## REQUEST

Current Zoning: ML-2 (manufacturing and logistics, 2)  
Proposed Zoning: MUDD-O (mixed-use development, optional)

Approximately 0.96 acres located at the southeast intersection of Thrift Road and Jay Street, north of Freedom Drive.

The petition proposes to allow uses in the MUDD zoning district with optional provisions on a parcel that is currently developed with commercial uses.

PROJECT: LUCKY DOG BARK AND BREW- 2220 THRIFT ROAD CHARLOTTE, NC 28205
 PETITIONER: LUCKY DOG CHARLOTTE PROPERTY, LLC
 15928 HENRY LANE HUNTERSVILLE, NC 28078
 SHEET TITLE: EXISTING CONDITIONS CONDITIONAL SITE PLAN
 SHEET: L1 OF 1

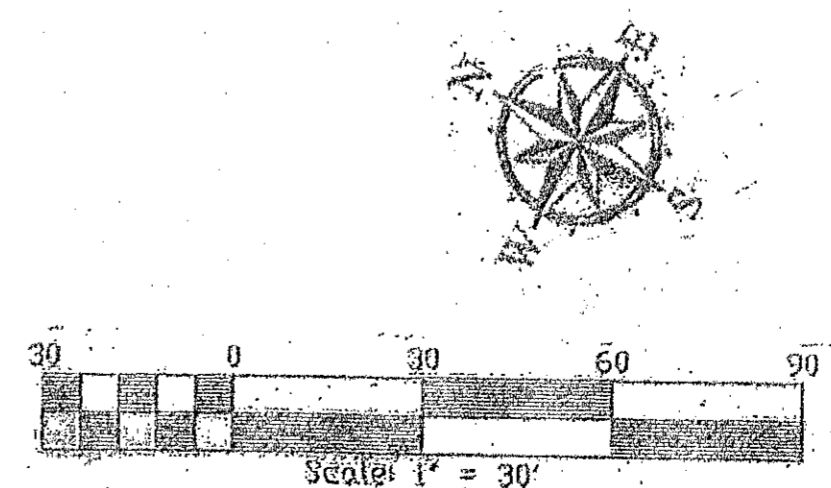
- ~~1. Include the minimum number of parking spaces that would typically be required on the site without the optional provision in addition to the listed number of parking spaces that will be provided with the optional provision.~~ **Addressed**
-
